from
**Southern
Water**

Your ref
Y/158/21/PL

Proposal: Demolition of existing dwelling and outbuildings and construction of 11 No dwellings (net increase 10 units) with access, landscaping and associated works (alternative to approved Y/121/19/PL). This site is in CIL Zone 3 and is CIL Liable as new dwellings & is a Departure from the Development Plan.

Site: Y/158/21/PL: - The Steddles, North End Road, Yapton, BN18 0DT.

Title Drainage GA

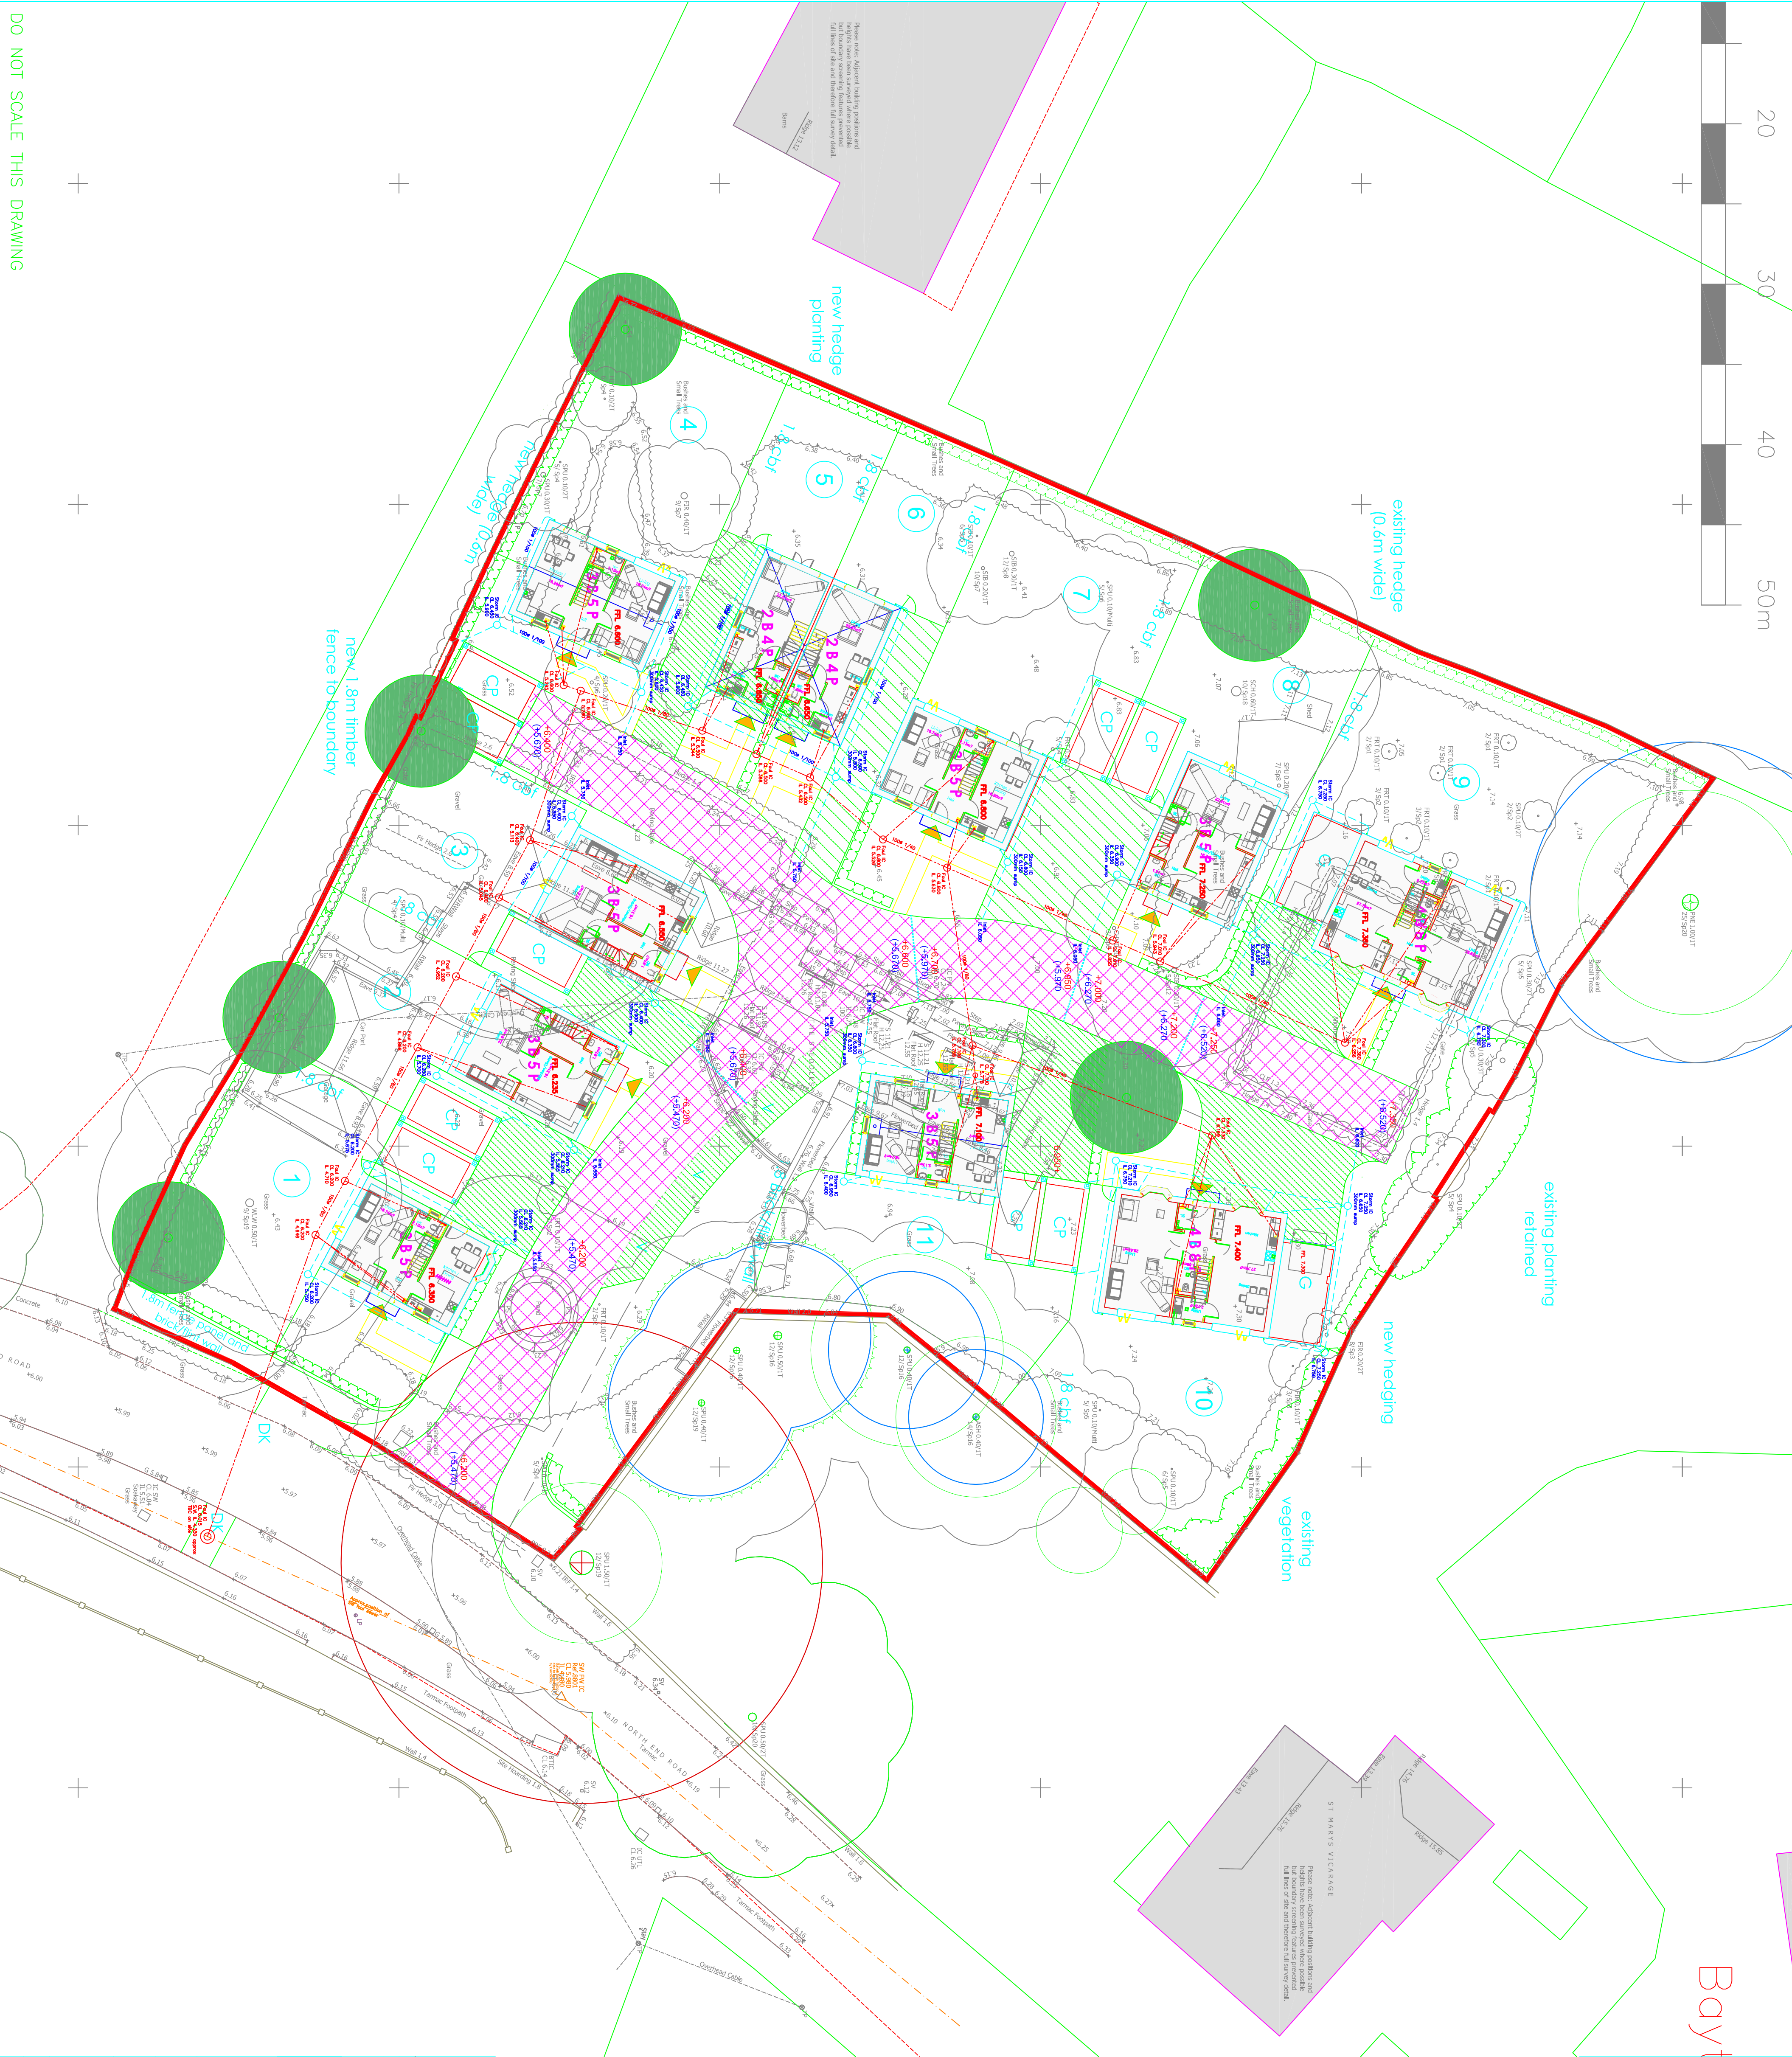
The Council's Building Control officers or technical staff should be asked to comment on the adequacy of soakaways to dispose of surface water from the proposed development.

Land uses such as general hardstanding that may be subject to oil/petrol spillages should be drained by means of oil trap gullies or petrol/oil interceptors.

The design of drainage should ensure that no land drainage or ground water is to enter public sewers network.

Due to surface water inundation issues in the Lidsey Catchment the applicant is advised to adopt, where appropriate, the measures in the table "Practical measures to reduce the potential impacts of development". Developer should look to protect the public sewerage system from inundation and infiltration, which contribute to flooding in unfavourable conditions.

We request that should this application receive planning approval, the following condition is attached to the consent: "Construction of the development shall not commence until details of the proposed means of foul and surface water sewerage disposal have been submitted to, and approved in writing by, the Local Planning Authority in consultation with Southern Water."

It is possible that a sewer now deemed to be public could be crossing the development site. Therefore, should any sewer be found during construction works, an investigation of the sewer will be required to ascertain its ownership before any further works commence on site.
